September 19, 2024

RE: Allaso Vineyards Apartments
8901 Holly Avenue NE
Permanent CO – Not Accepted
Engineer's Certification Date: 09/17/2024
Engineer's Stamp Date: 11/19/21
Hydrology File: C20D086

Based upon the information provided in your submittal received 9/13/2024, and the site visit on 9/17/2024 the project is not approved for Permanent CO.

SHEET TITLE:  
GRADING 2

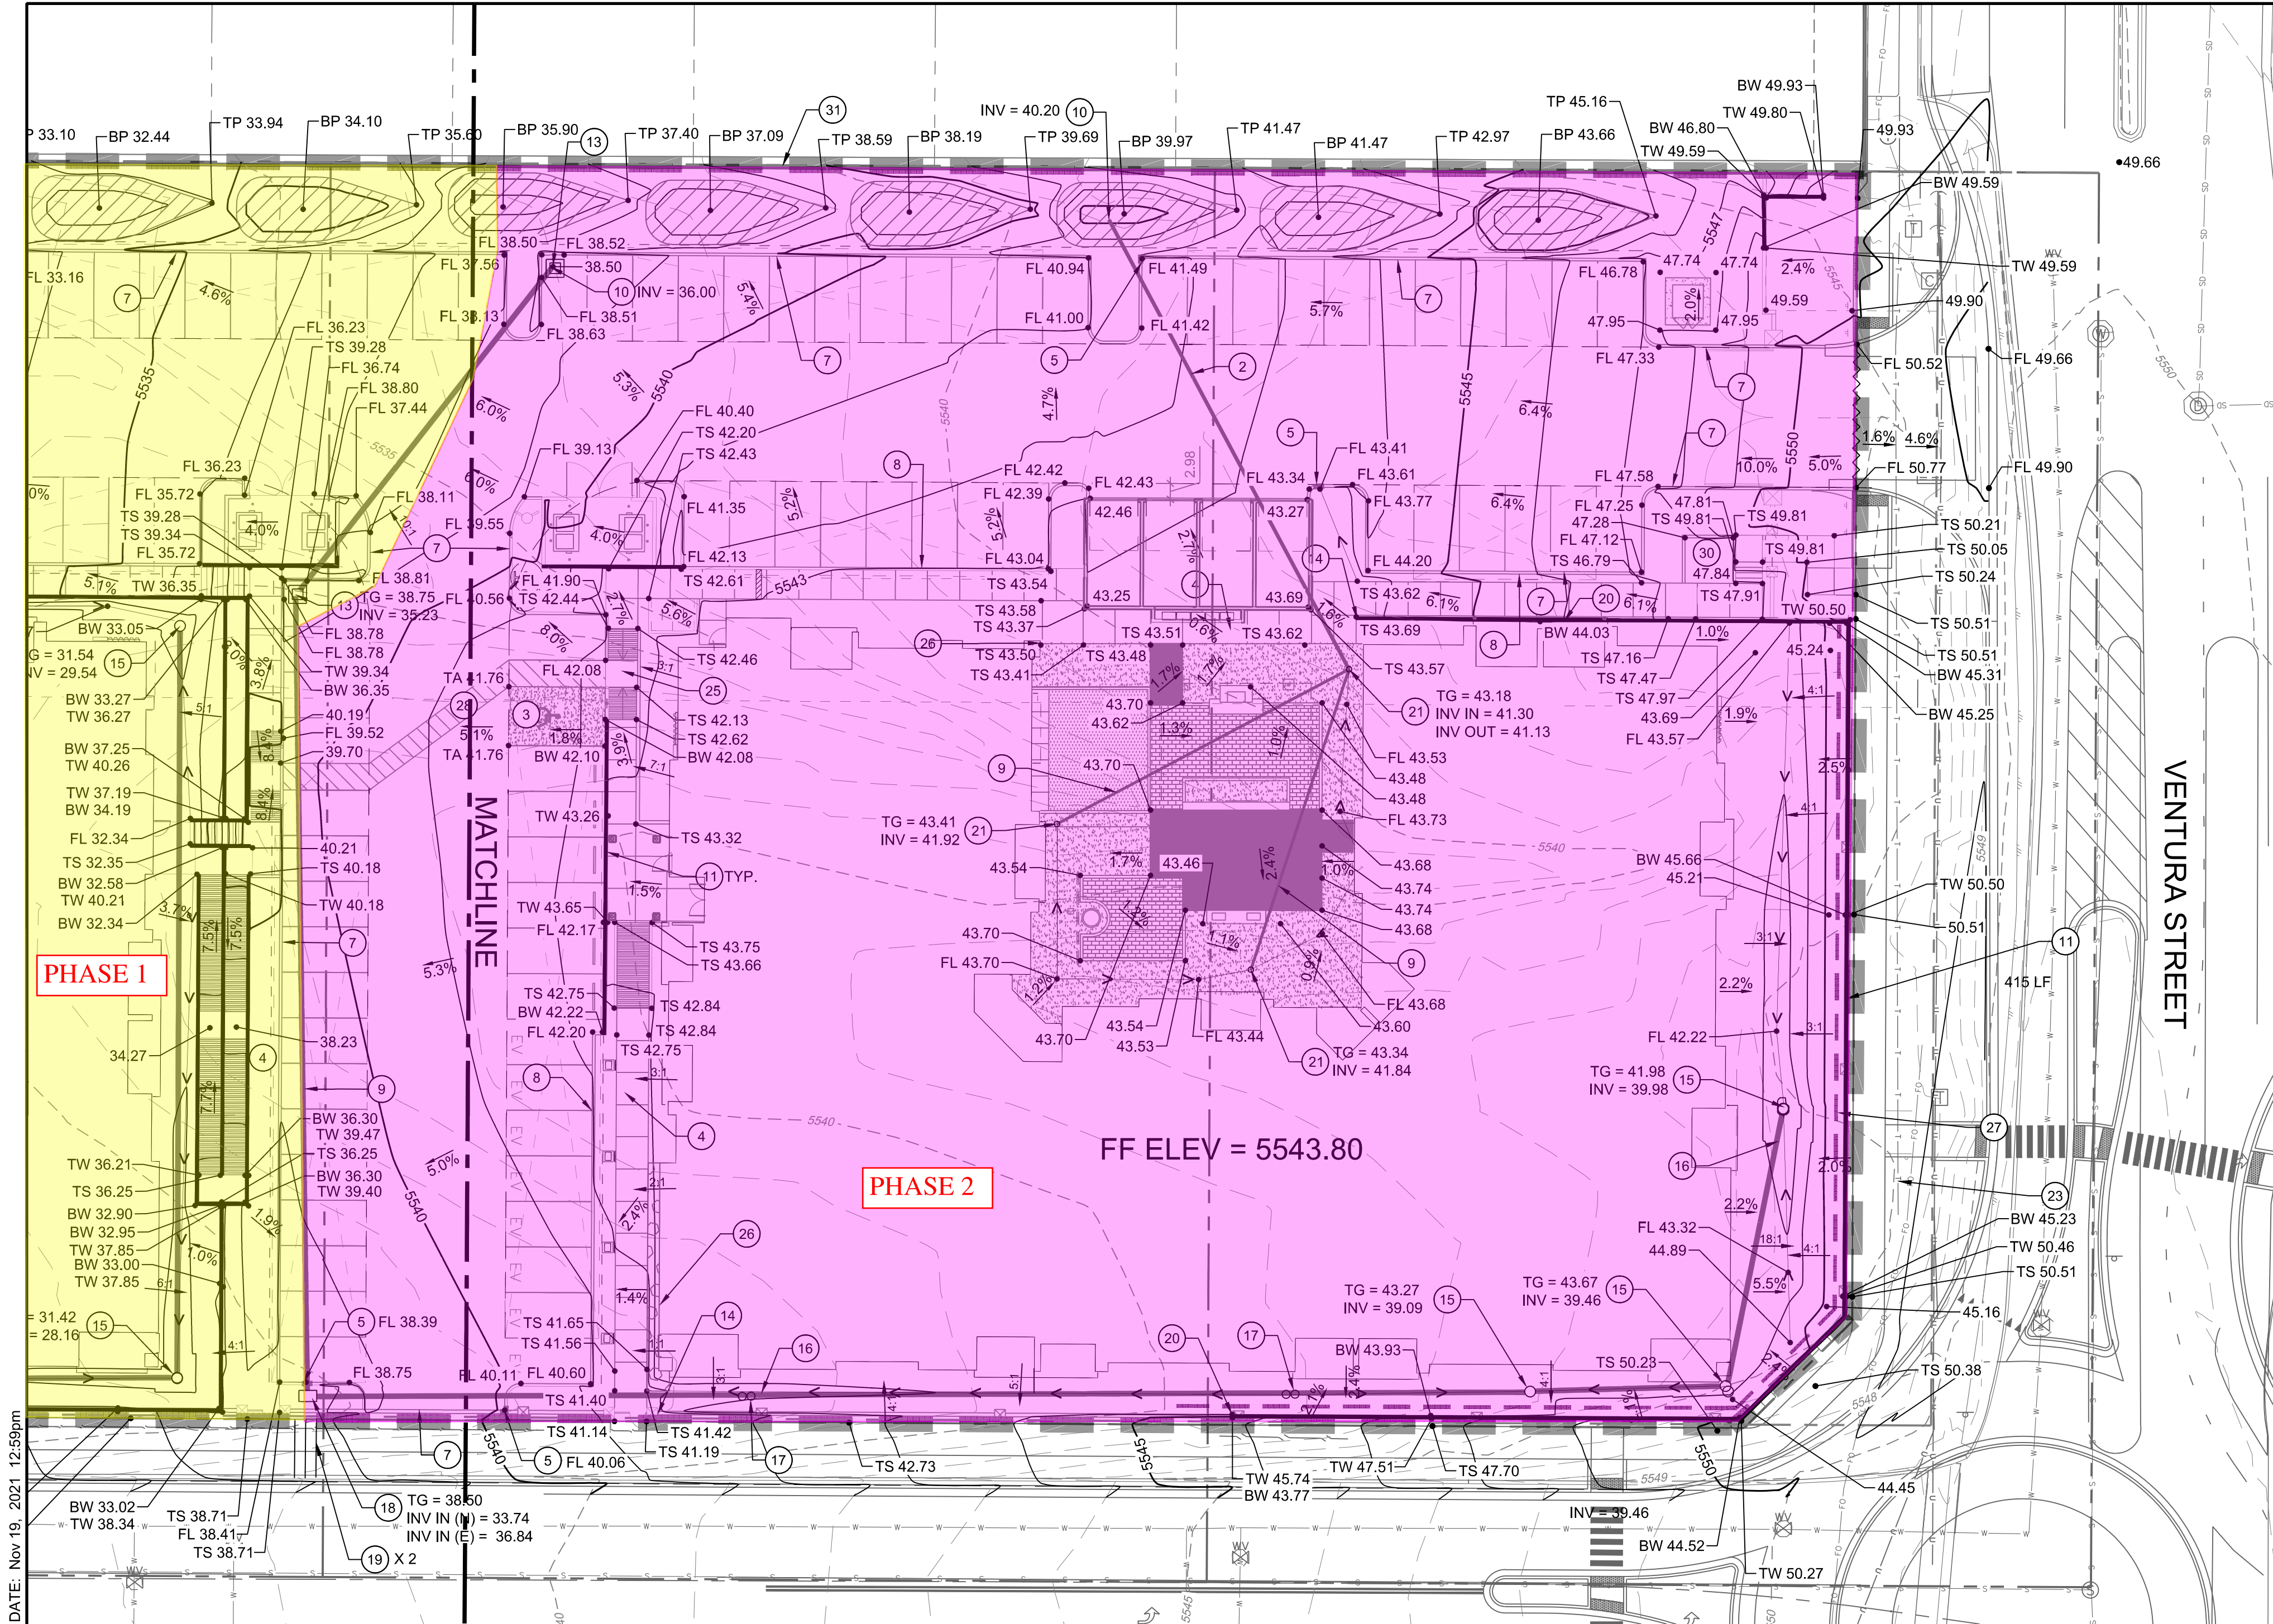
1. C-102: The area to the east of the building, and the area along the NE corner is of concern regarding possible flooding to the adjacent apartments. There does not appear to be a slope away from the building into a swale that directs the storm water to the drop grate (see areas in yellow showing where the slope needs to be looked at. The area where the swale is supposed to be located appears to be flat and not sloped according to the cross sections shown on C-104. Also of concern is the elevation of the drop grate. Please check and verify that the As-built elevation is low enough to capture the storm water intended to prevent flooding of the nearby apartments. From the field, it appeared that the elevation might be at the same or higher elevation than the finished floor.
